Application Ref:	3/2025/0507			 <p>Ribble Valley Borough Council www.ribblevalley.gov.uk</p>
Date Inspected:	22/07/2025	Site Notice:	22/07/2025	
Officer:	MC			
DELEGATED ITEM FILE REPORT:				APPROVAL

Development Description:	Application for Planning Permission for conversion of barn to create new dwelling. Demolition of existing farm block.
Site Address/Location:	Lower Reaps Farm, Whinney Lane, Mellor BB2 7EL

pl.10

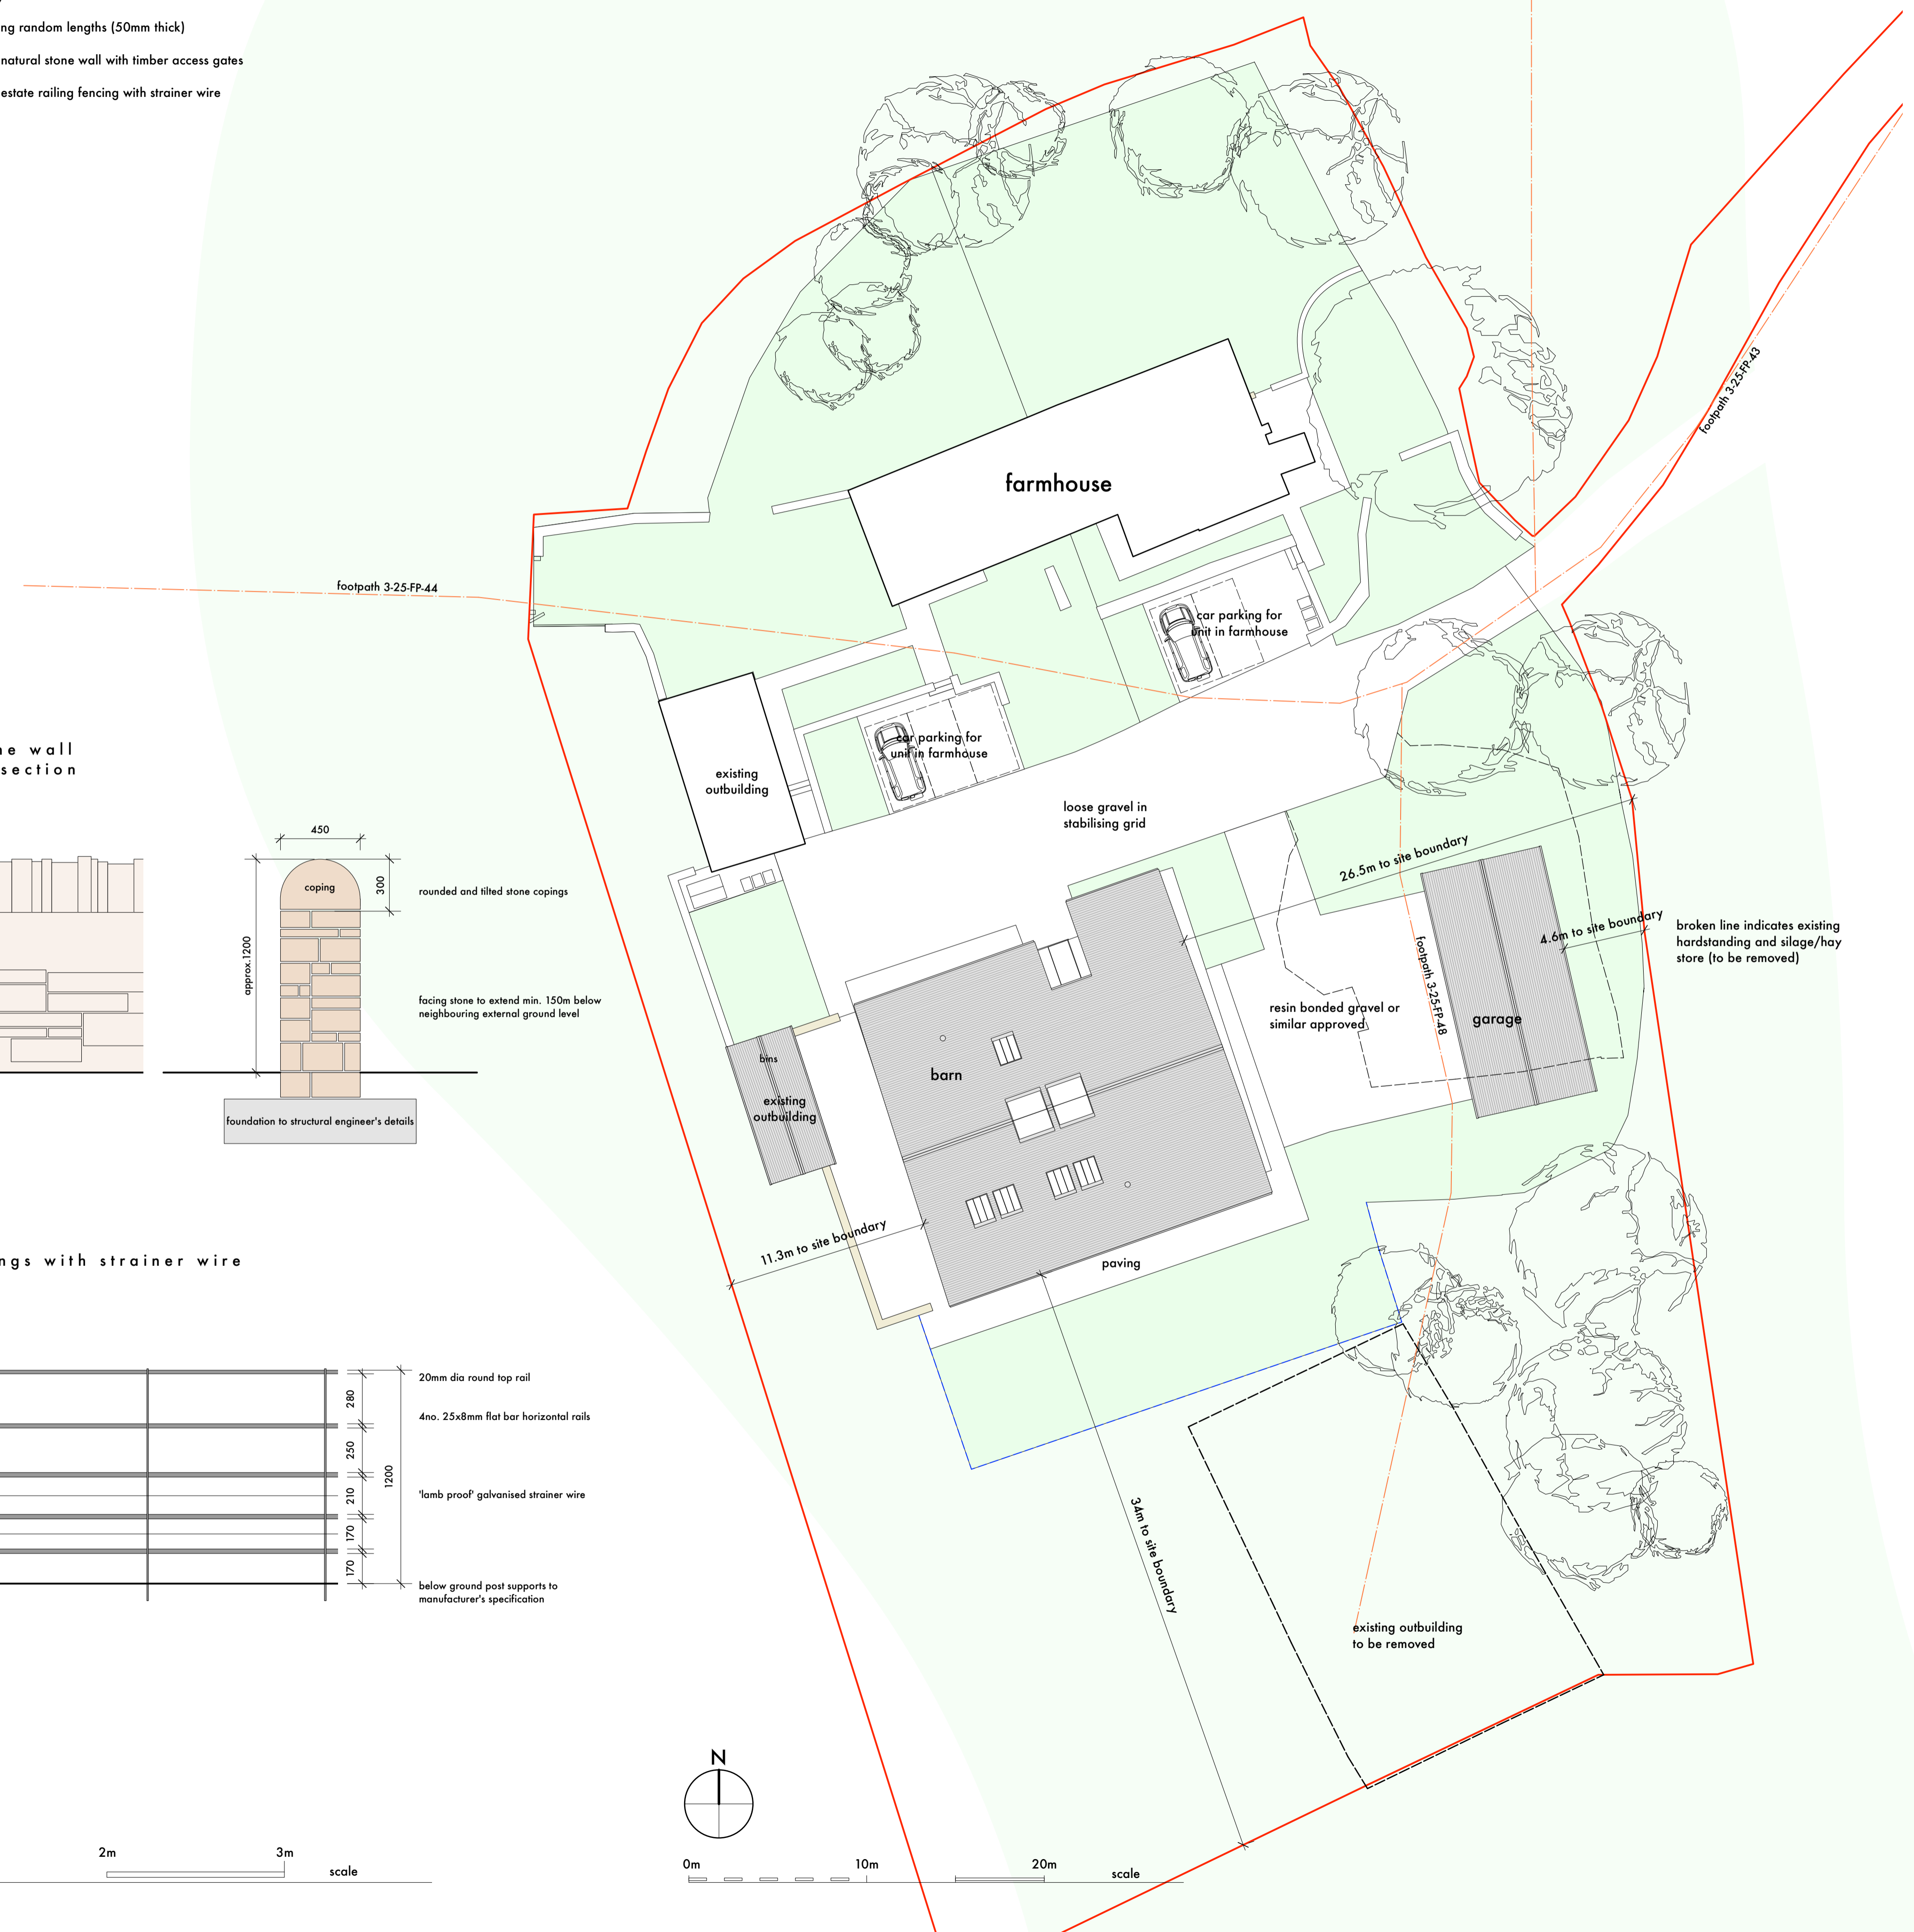
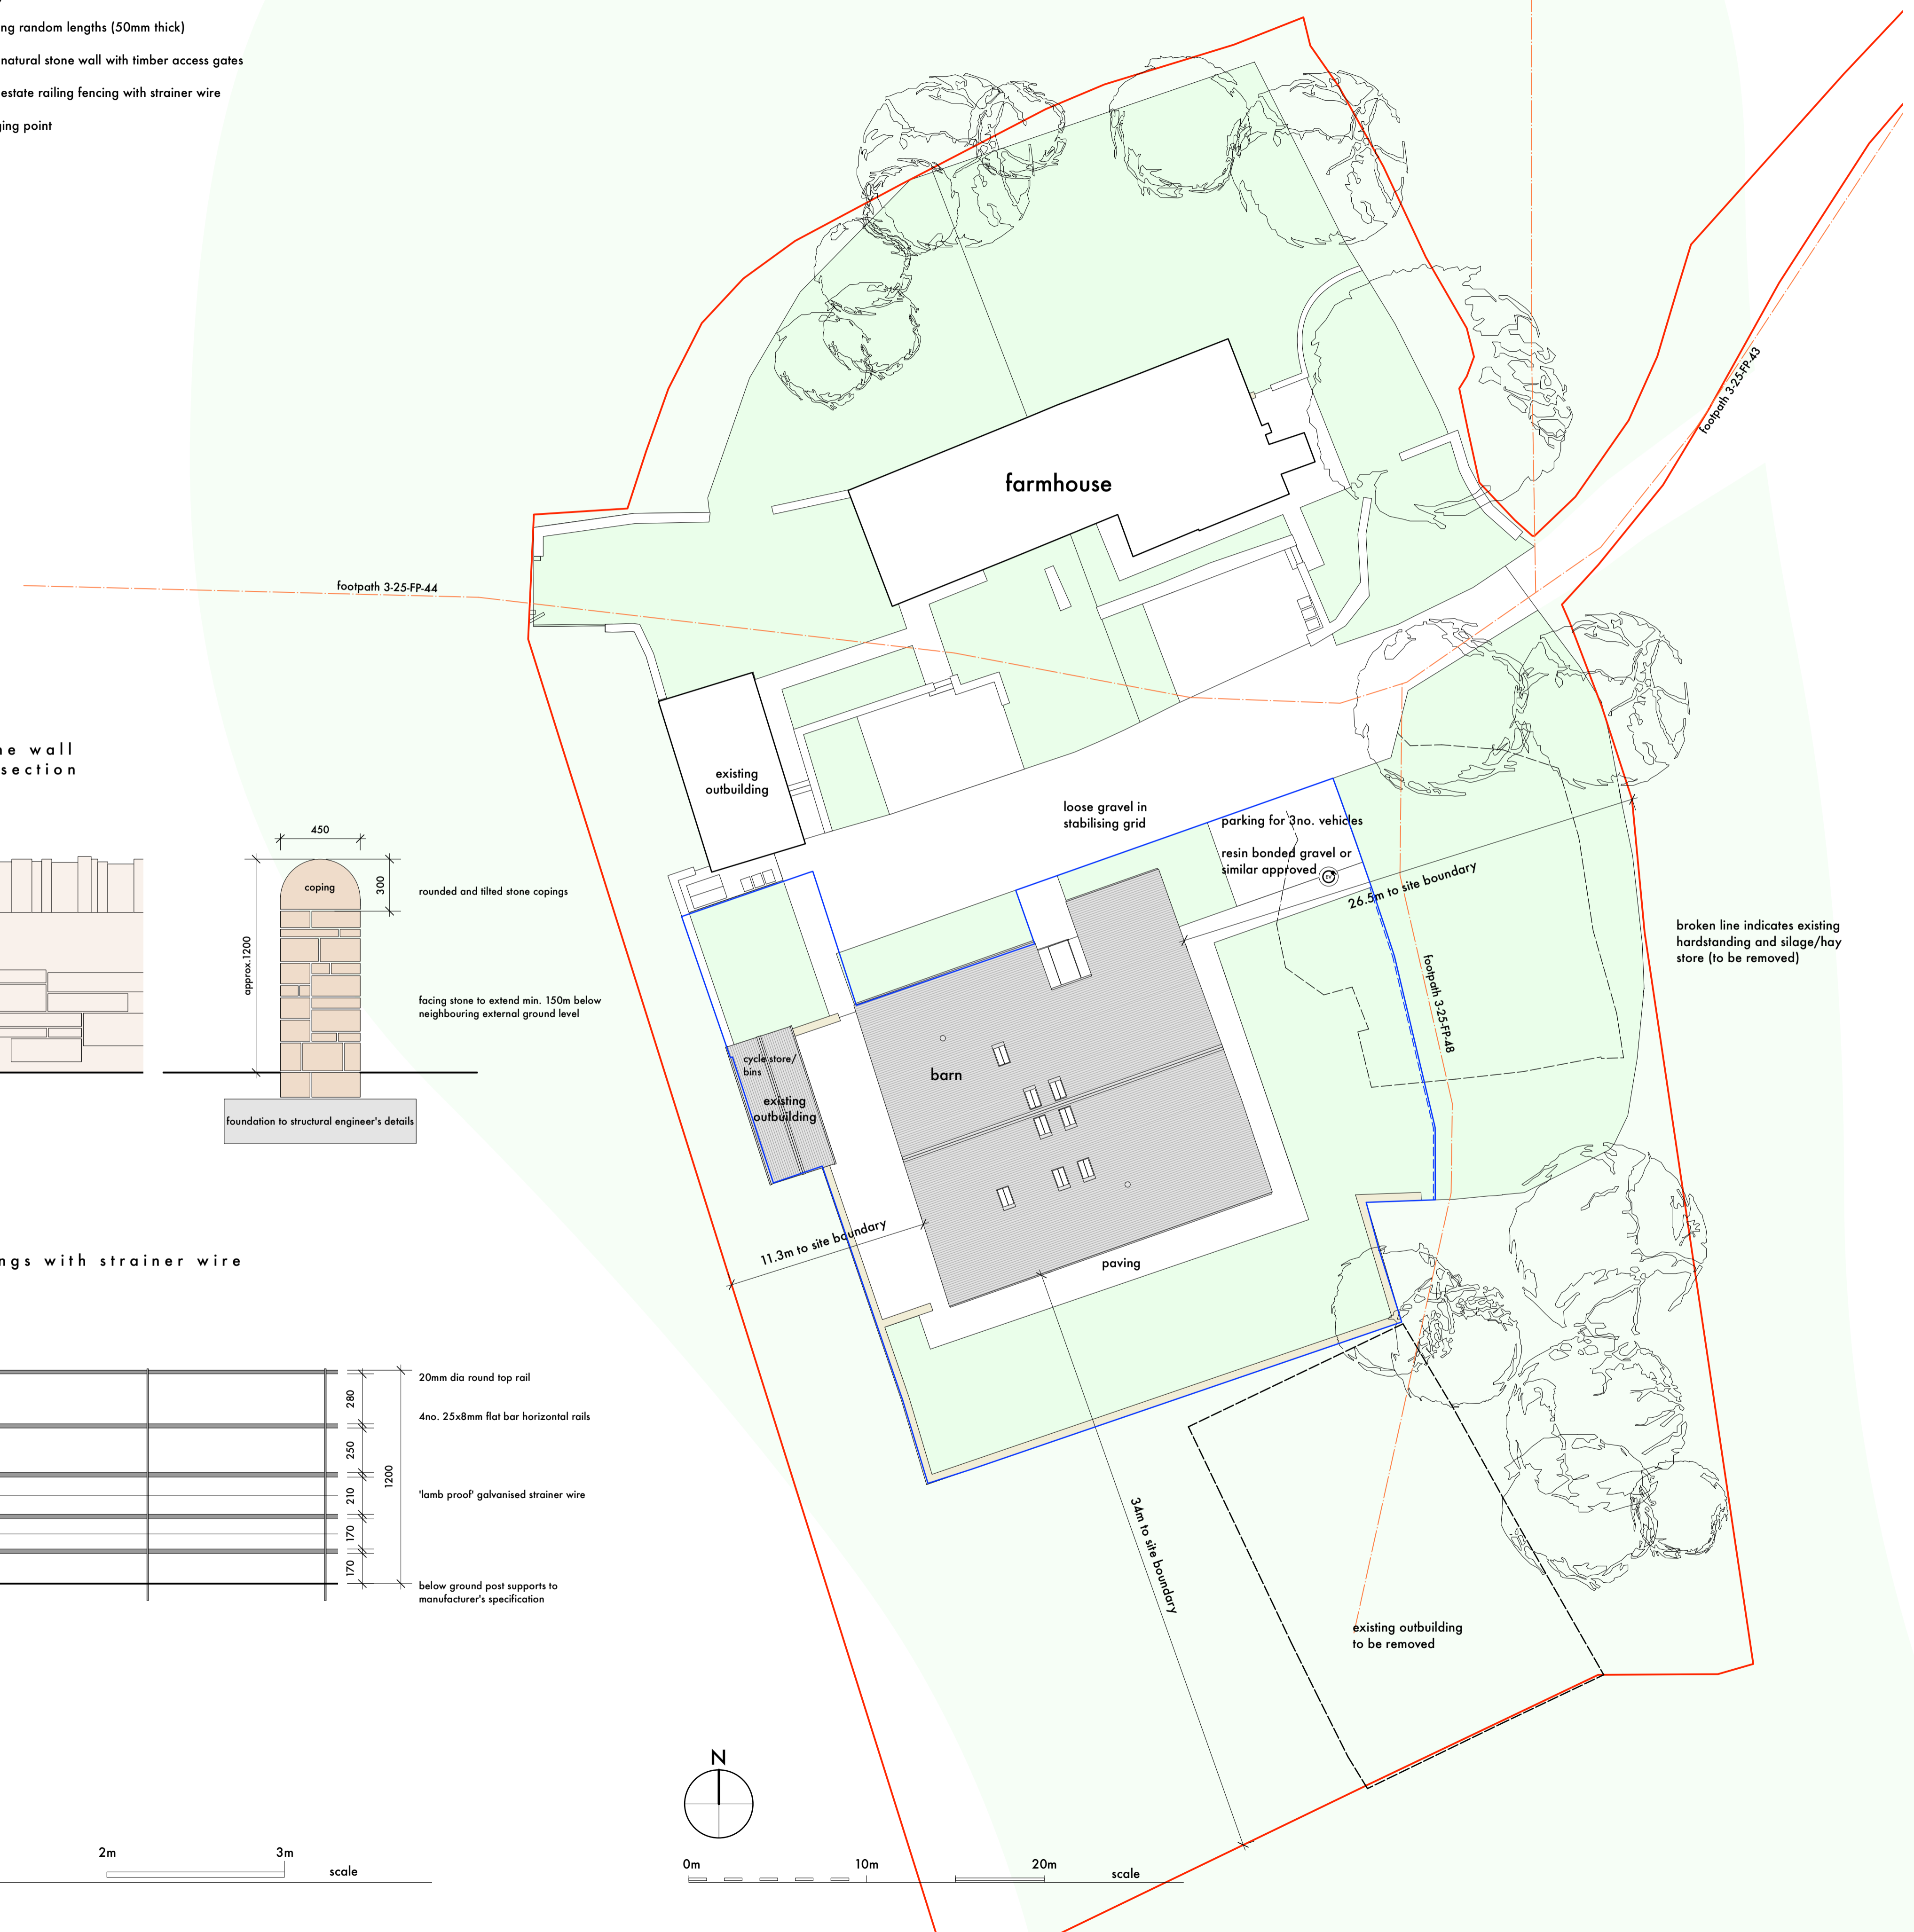
- Remove detached garage from the scheme
- Reduce the width of openings to the south elevation
- Removed the parking areas associated with the listed farmhouse from the site plan as these do not relate to this application
- Removal of larger parking area to the west of the barn following comments received from LCC Footpath Officer.
- Alterations to rooflights

The proposed garage has now been removed from the scheme. In addition, the dilapidated barn to the rear of the barn for conversion is proposed to be removed. The parking area has also been amended so that it is now the same extent as the extant scheme following comments received from LCC Footpath Officer. As such,

The removal of the larger parking area to the east of the barn also addresses concerns raised from the Public Rights of Way Team at Lancashire County Council and the parking area would now not obstruct footpath 325FP48 as the routes would pass by the buildings in the same way as existing and the improvements and re-use proposed are considered to enhance the users experience. It may well be that some of the public footpaths would pass close to or within residential curtilage but this is not unusual in a rural setting such as this and no proposals to enclose or affect these have been made.

An updated plan has been submitted which now shows the passing places to be implanted and the proposed site plan has also been updated to show the proposed cycle storage within the existing outbuilding. As such, these can now be conditioned appropriately.

**north elevation**

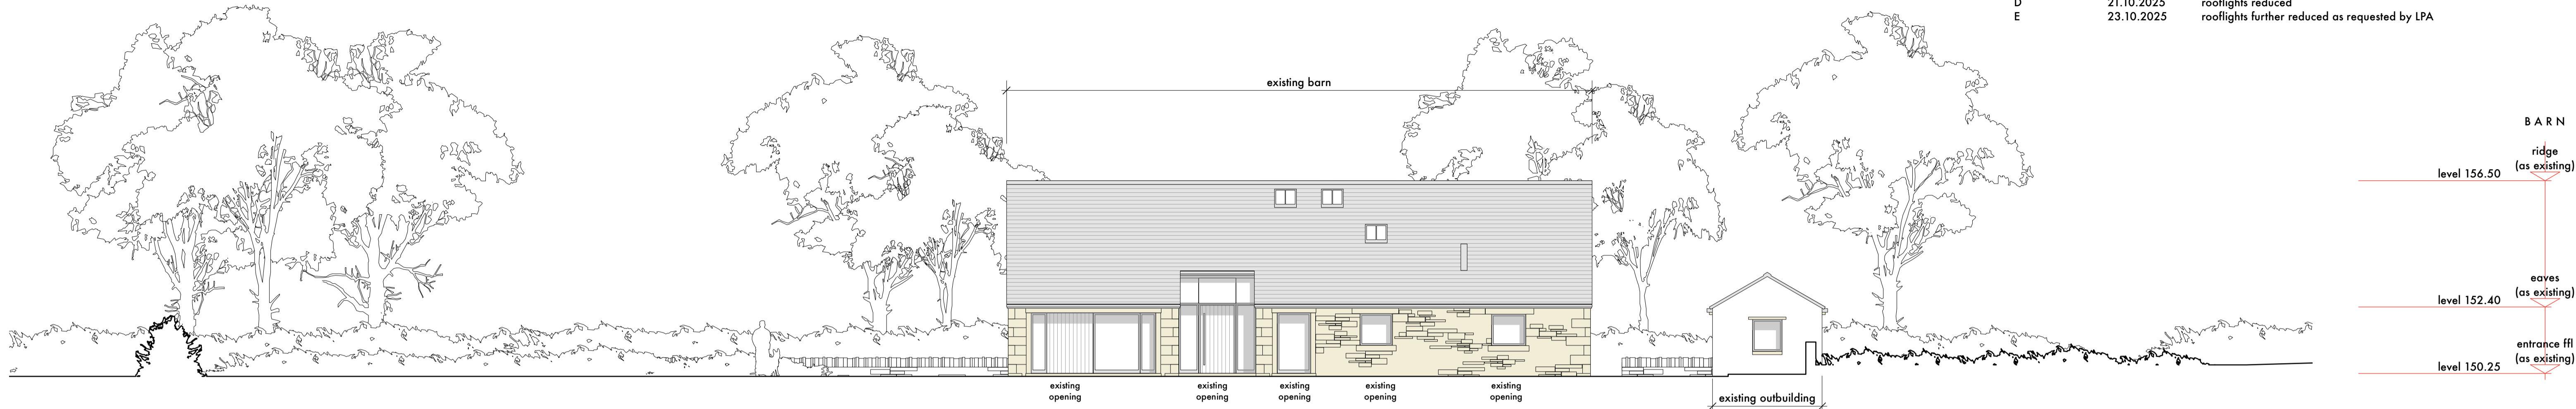
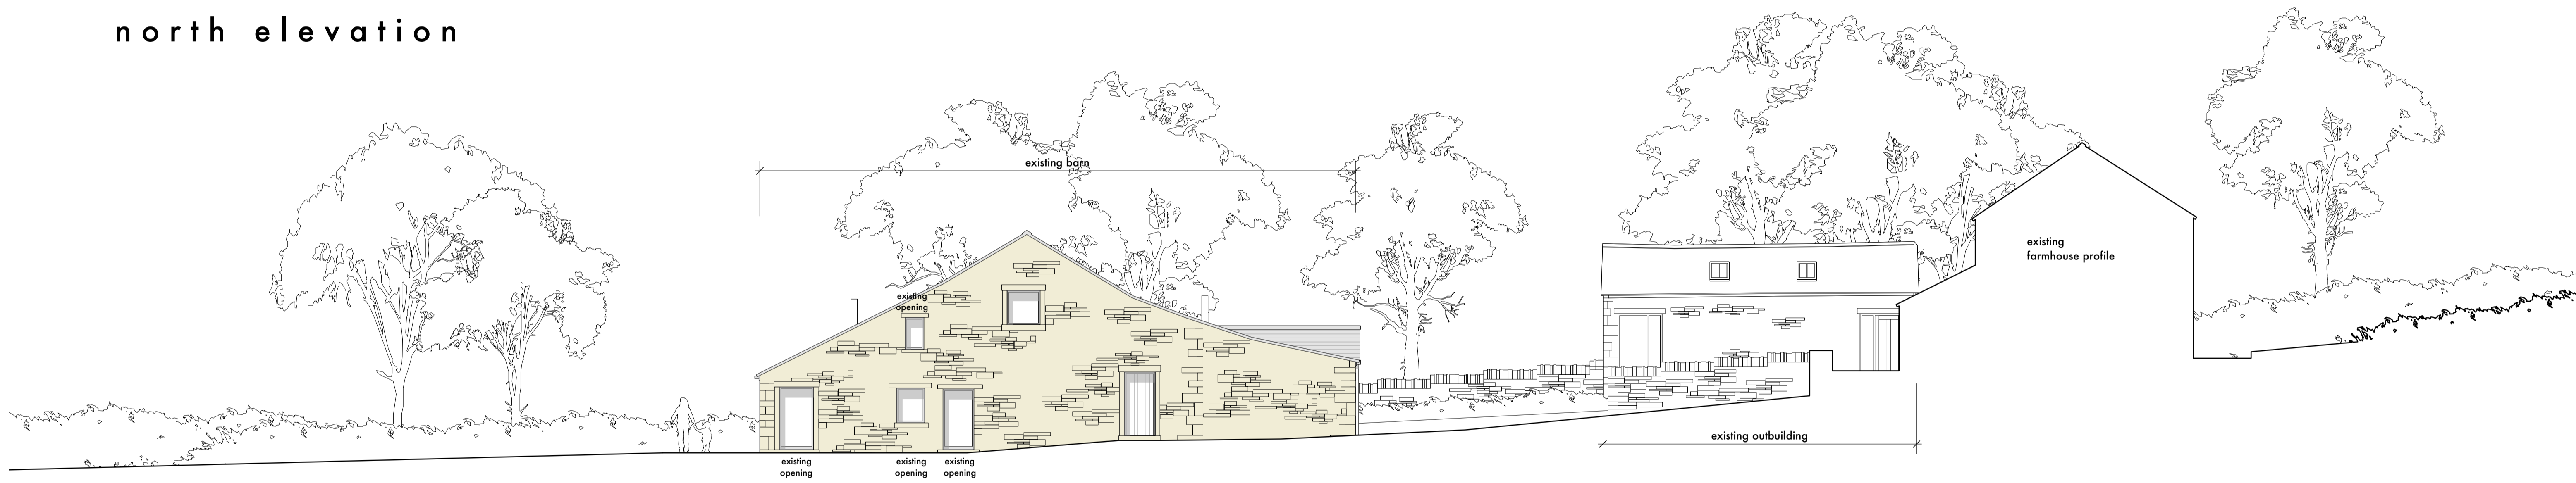
The northern elevation would re-use existing opening which would include large, glazed openings. However, the Conservation and Heritage Officer notes that the level of glazing proposed to the northern elevation is less than the approved scheme and as such, this would be an improvement. Any harm is considered to be negligible.

Following ongoing discussions between the Planning Officer and agent for the application, the ridge lights have now been amended to conservation style rooflights to ensure that the historic character of the barn is retained.
